Pearl Place 2

184 Pearl Street, Portland, Maine

Addendum No. 3 to Contract Documents

August 25, 2011

C2 EXTERIOR ELEVATION WEST - A WING
 1/8" = 1'-0"

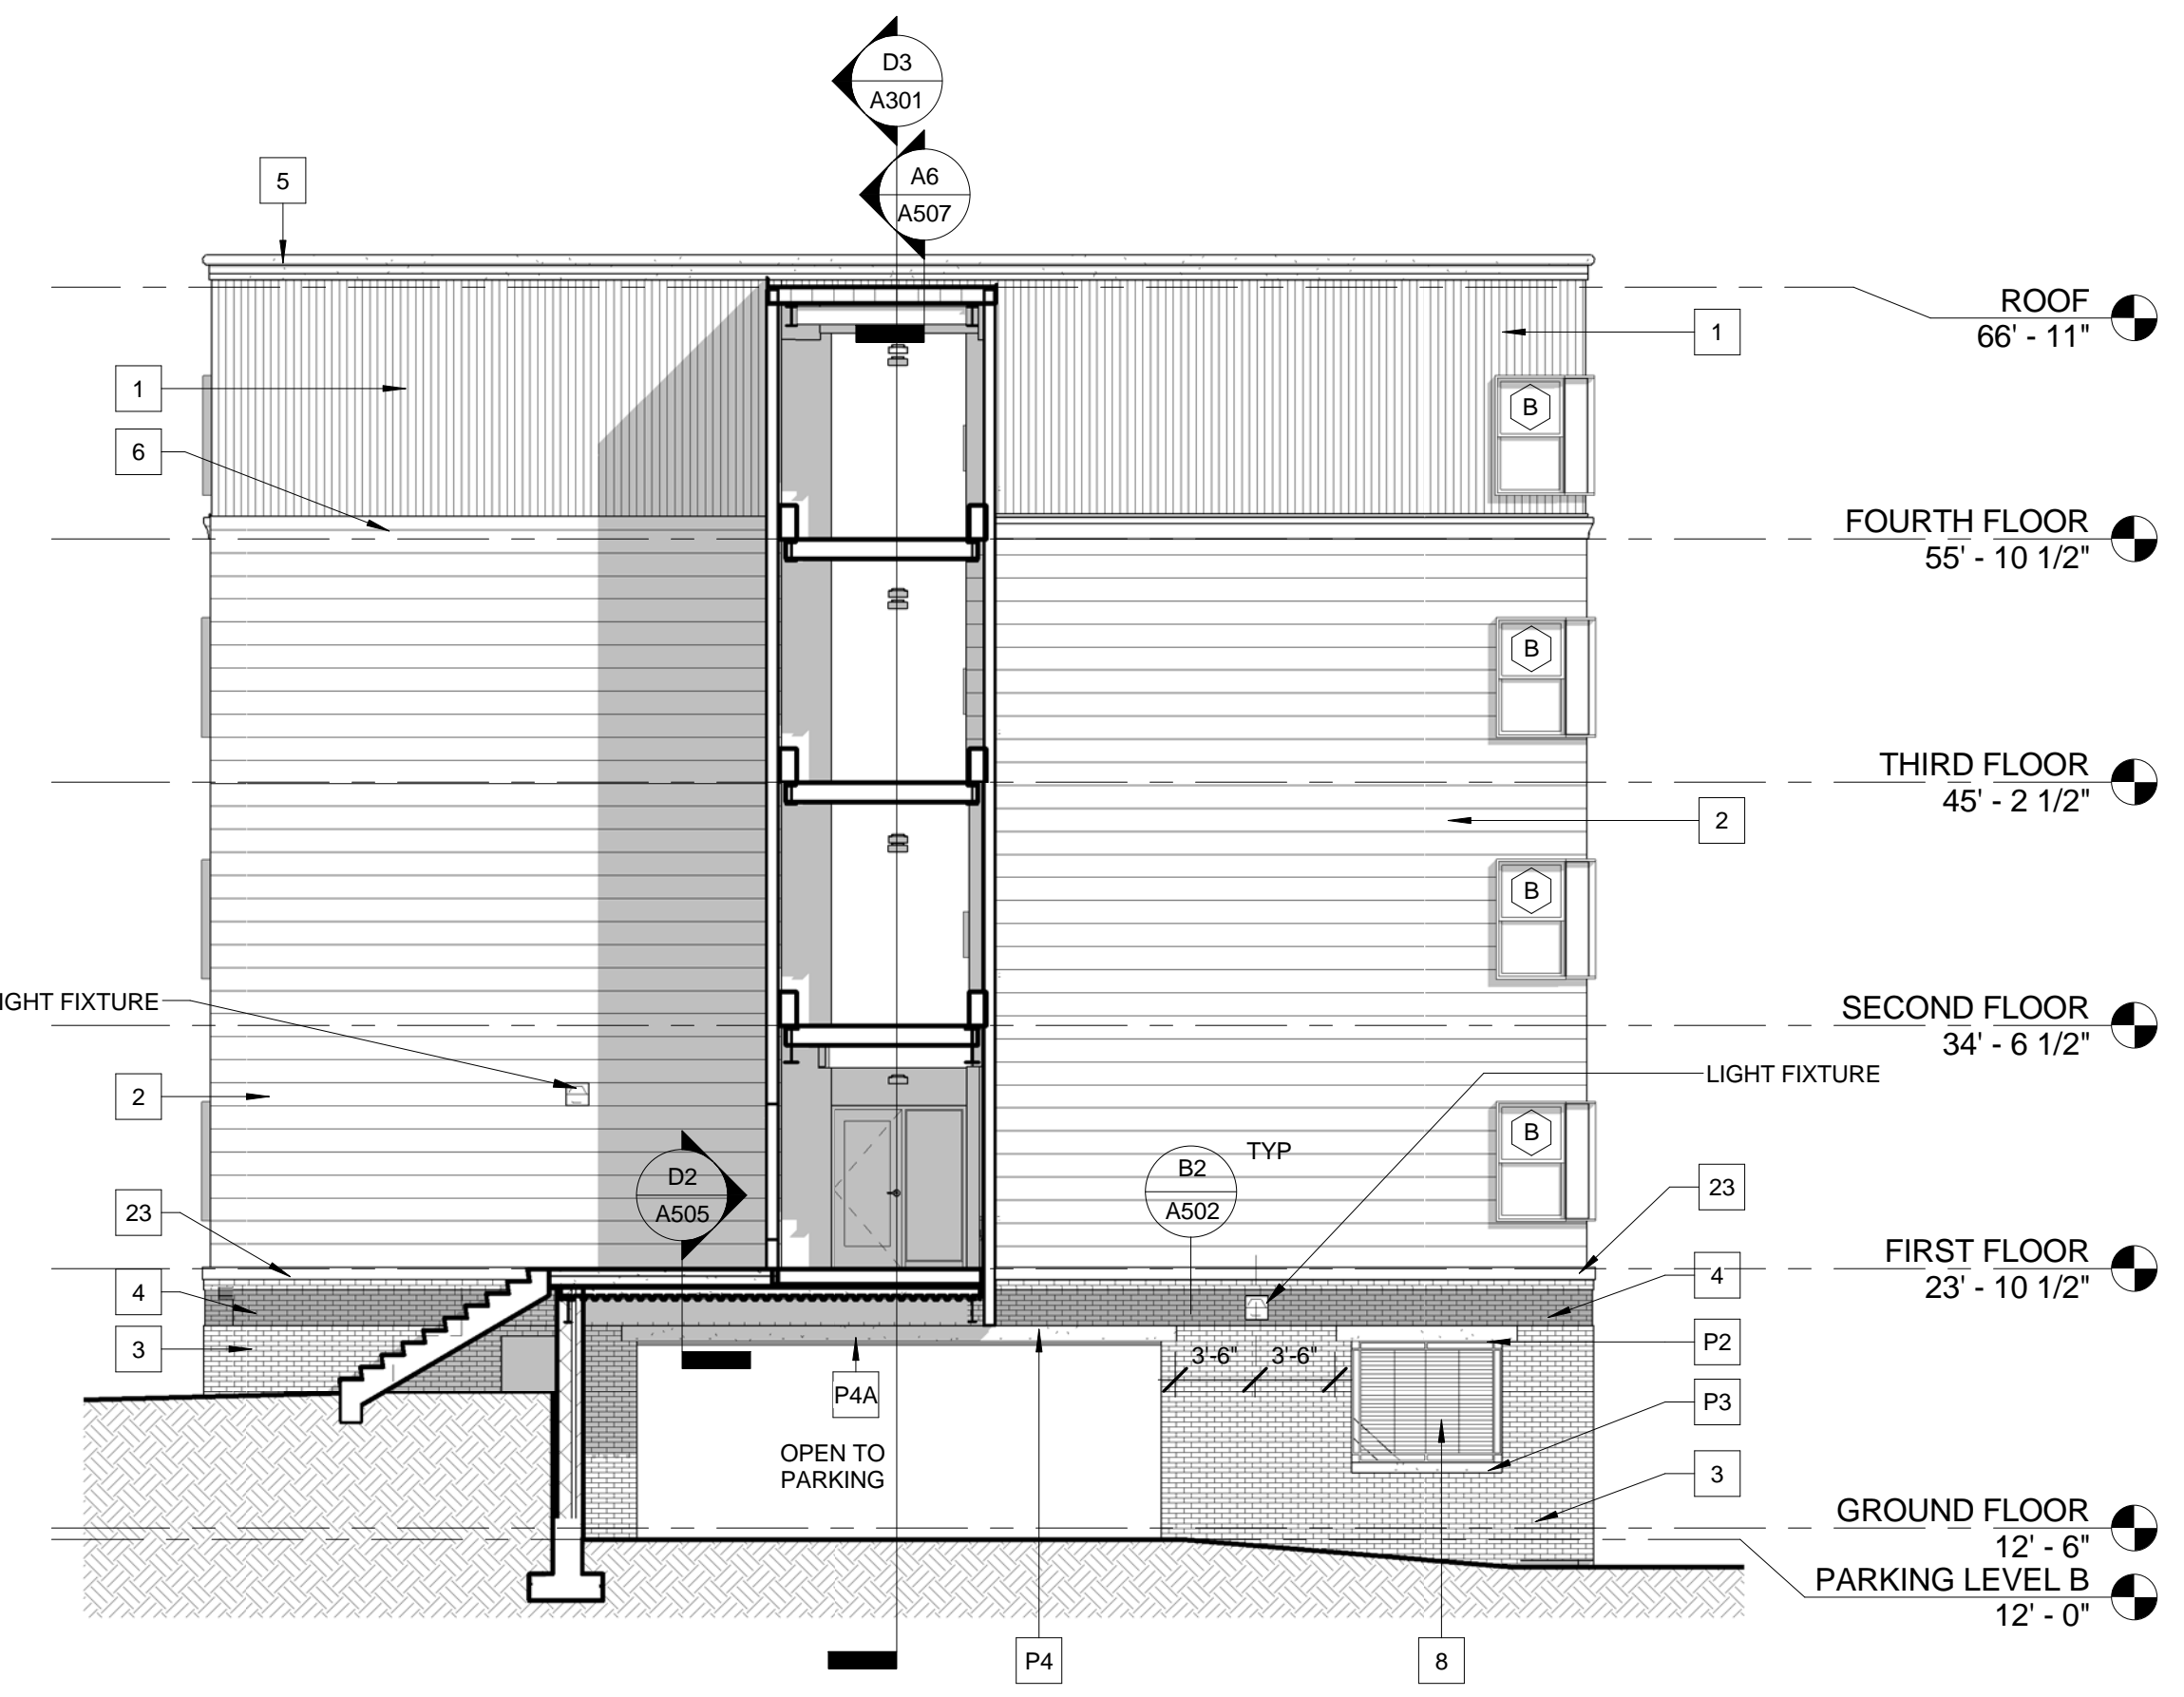
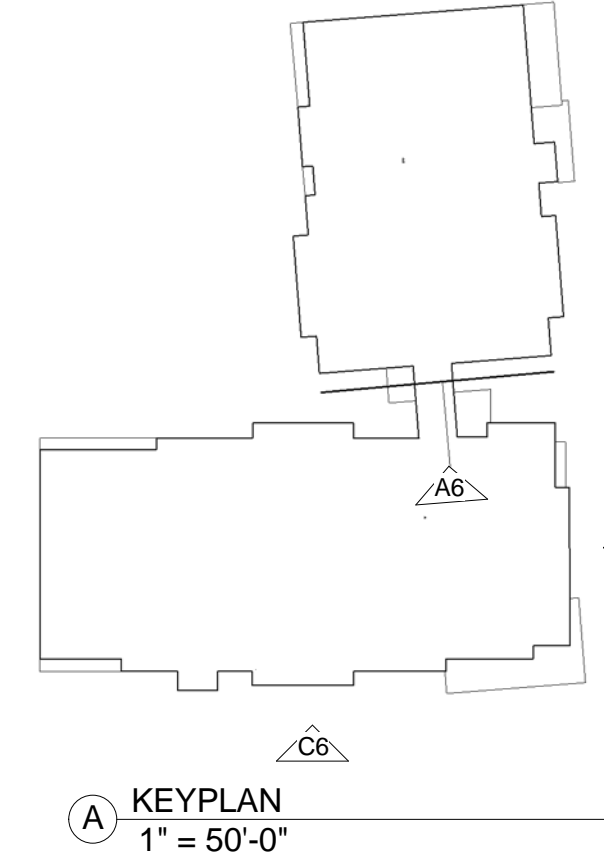
- G. Drawing A104: ADD: door 408K.1 to the bathroom of Unit 408 in location to match Unit 308 at floor below.
- H. Drawings A200 & A201 Elevation Keynotes # 8: ADD “ See Sheet A-511”

FOURTH FLOOR FRAMING PLAN
1/8"=1'-0"

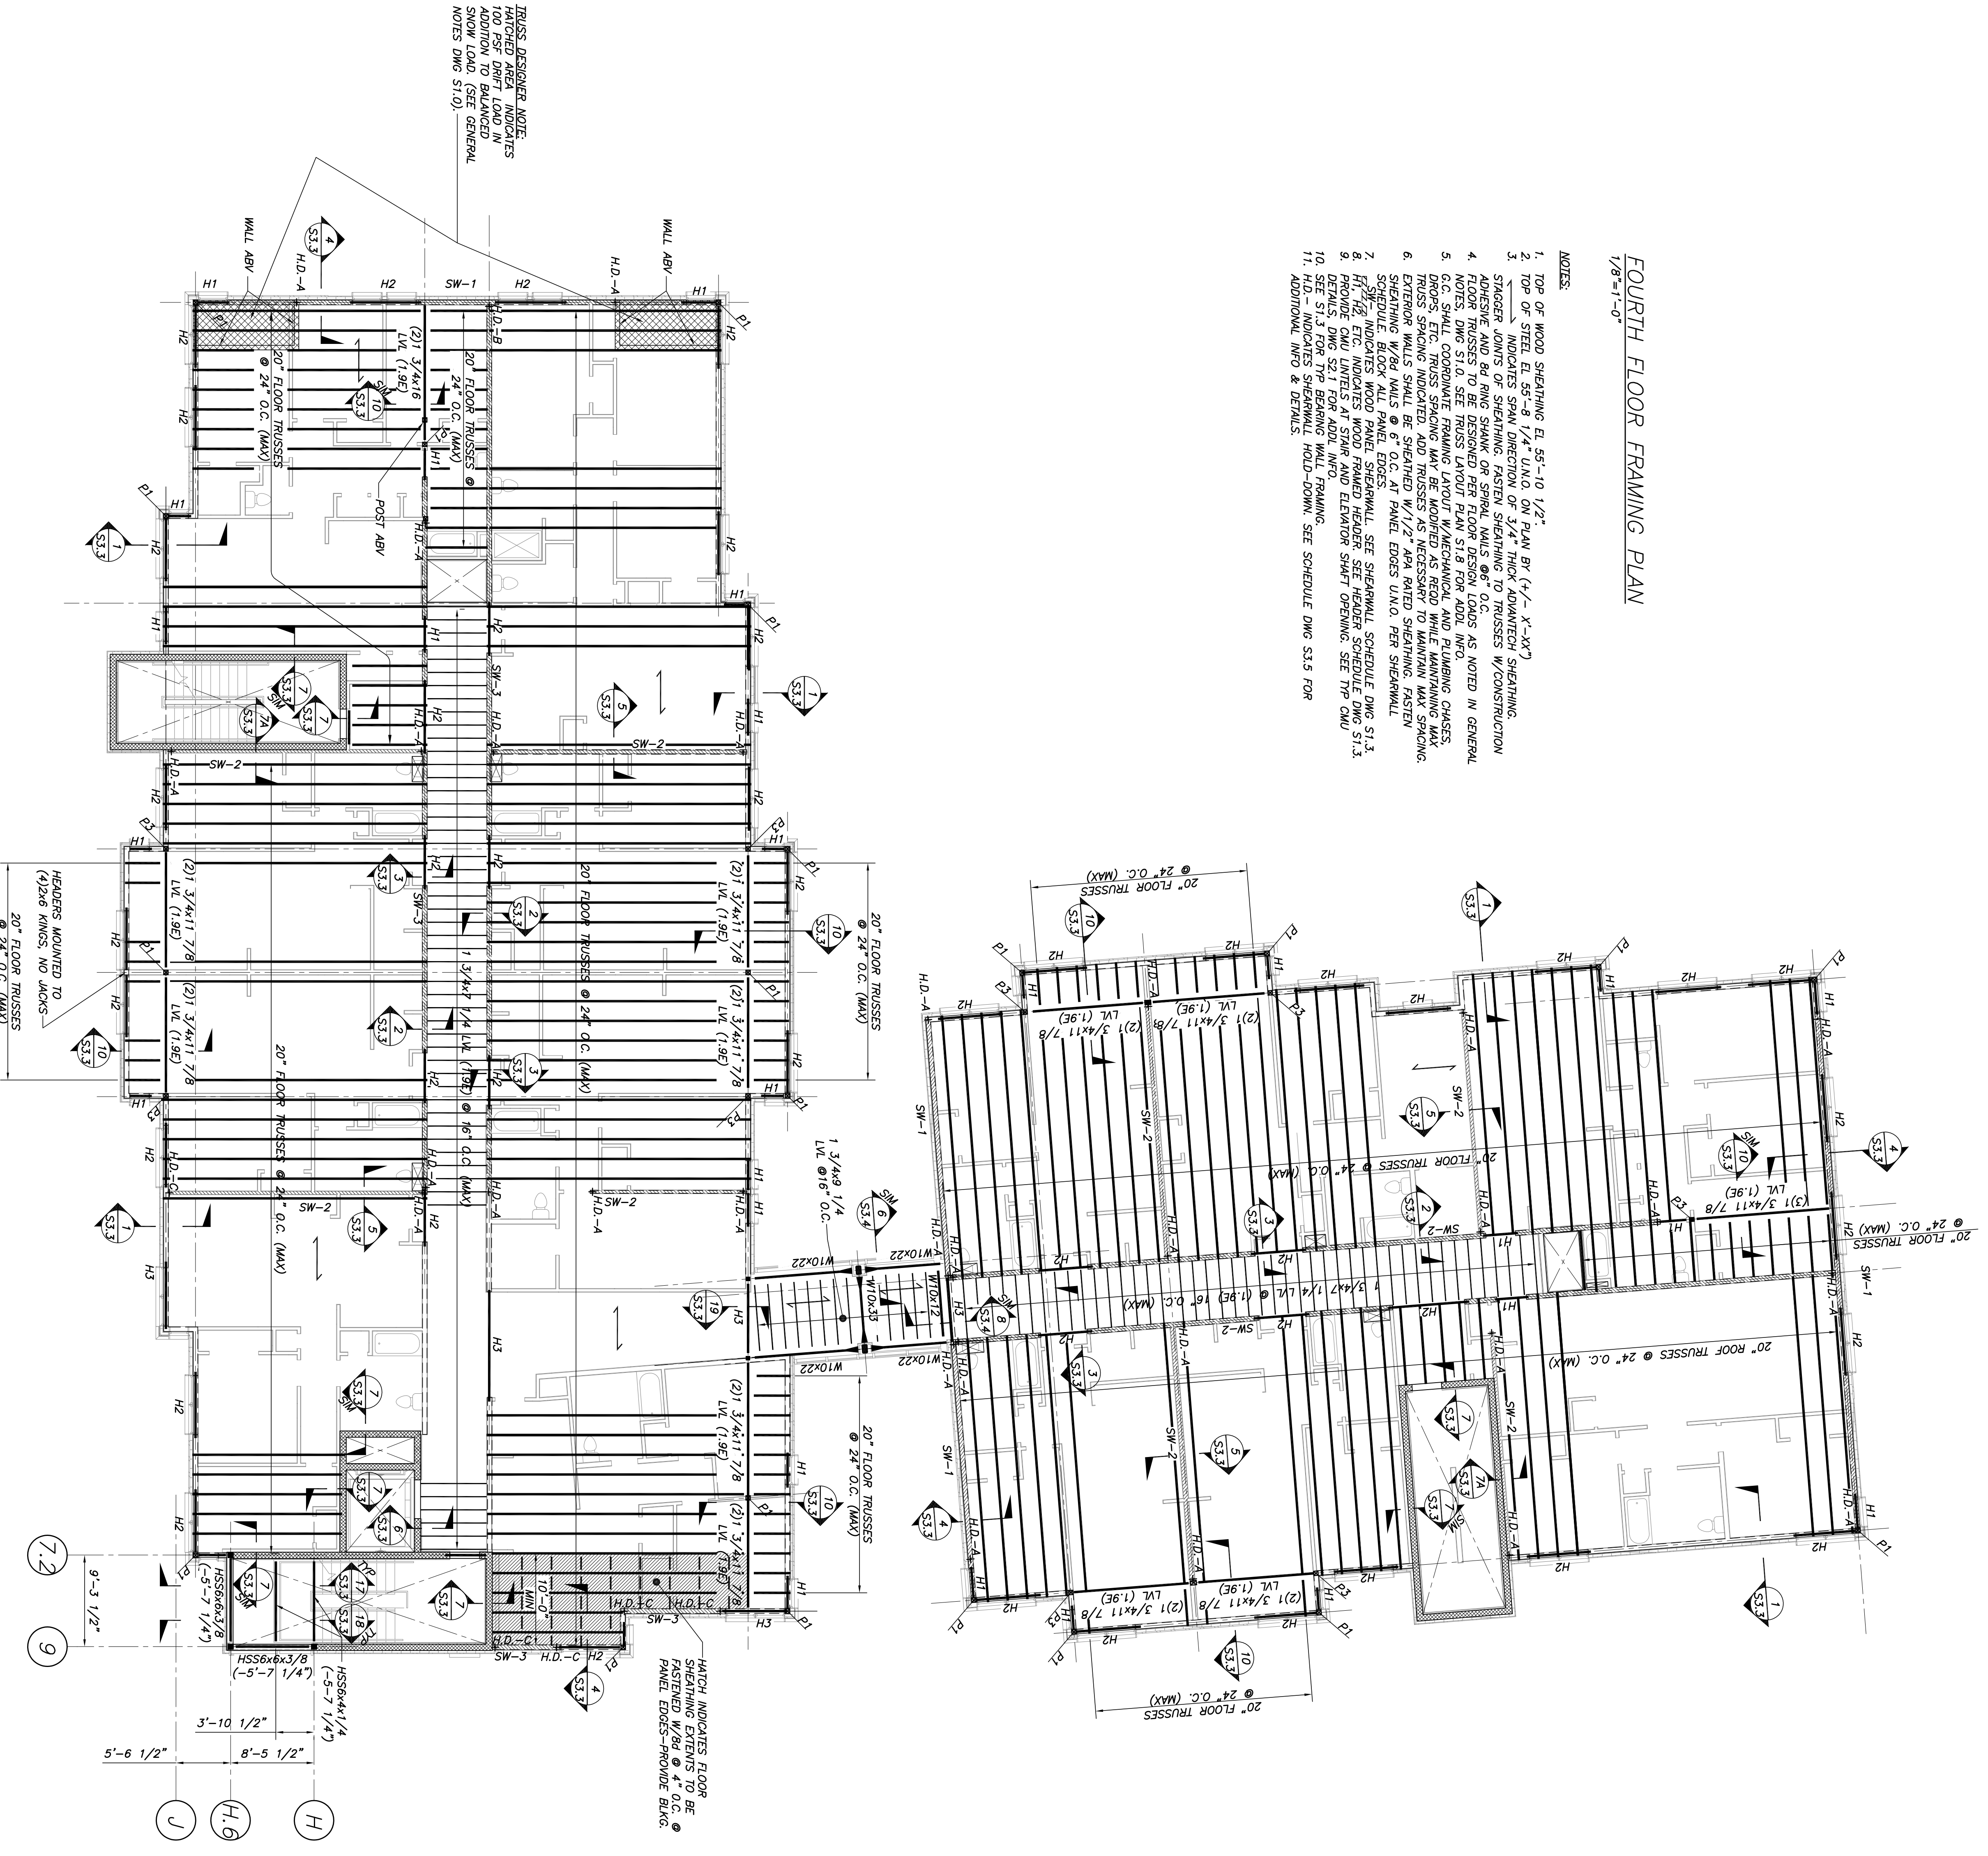
- A. Drawings S1.4 and S1.5: DELETE all notes for “P4” posts
- B. Sketch SKS-1 Revision 1 is hereby attached
- C. Sketches SKS-2, SKS-2, SKS-3, SKS-4, and SKS-5 are hereby attached to document relocation of column line B.
